Your ref: 21.1248
Our ref: D3.21.1248
Date: 21st January 2022

App no: 21.1248

Address: Duke of York Inn Grindleton Brow Grindleton

Proposal: Change of use from public house with living accommodation to residential use. Demolition and replacement of single storey extensions, alterations to vehicle access and landscaping. Following refused applications 3/2019/0049 and 3/2020/0219

Drawing Title
Proposed Site Plan and Sections

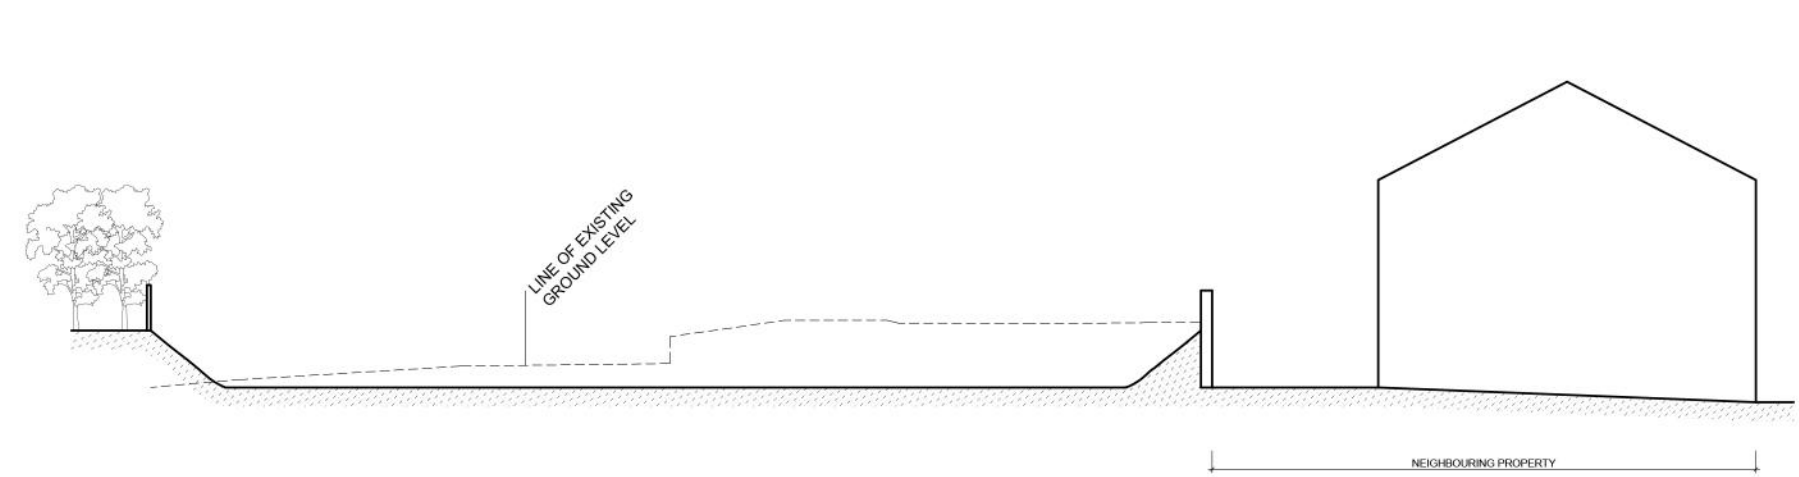
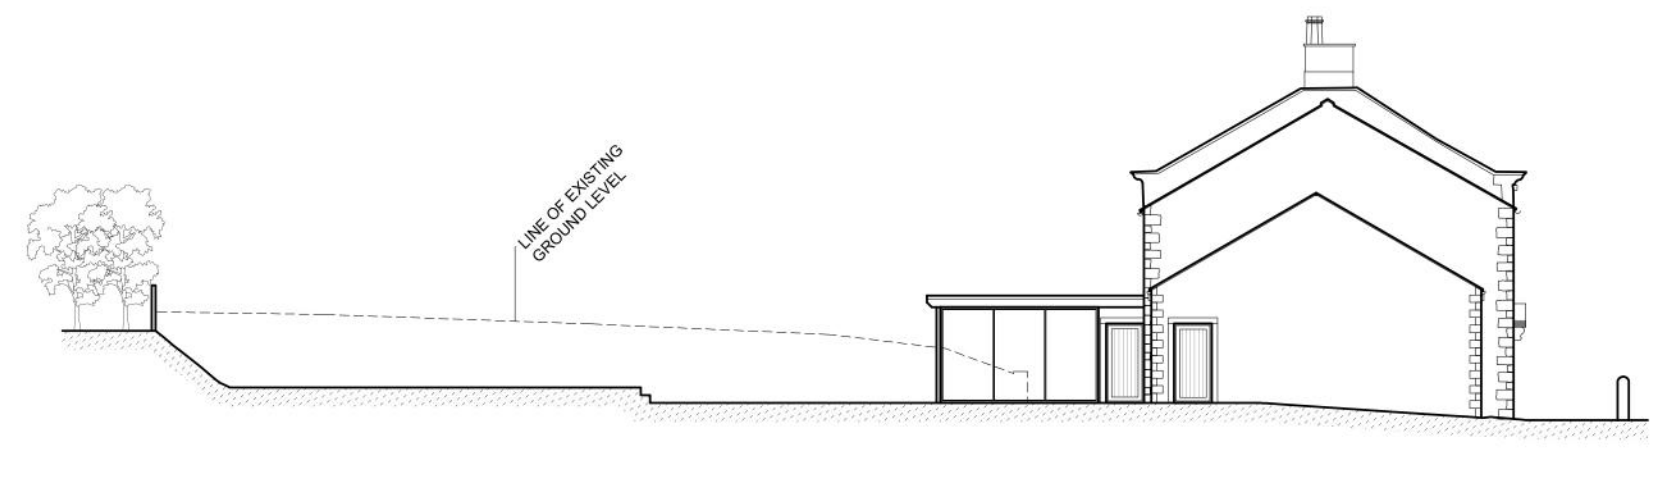
The boundary walls to Grindleton Brow all need to be constructed and maintained below 1m high to ensure adequate visibility is provided for emerging vehicles.

There are minor alterations proposed to the alignment of the existing paved access which requires tie in detail to the adopted highway. This should be completed under and an agreement with Lancashire County Council.

A secure, covered cycle store and electric vehicle charging point are requested to support sustainable travel.

1. The boundary walls to Grindleton Brow shall be kept at or below 1m high for highway safety reasons.
2. Prior to first occupation of the development hereby permitted, there should be a secure, covered cycle store and an Electric vehicle charging point.
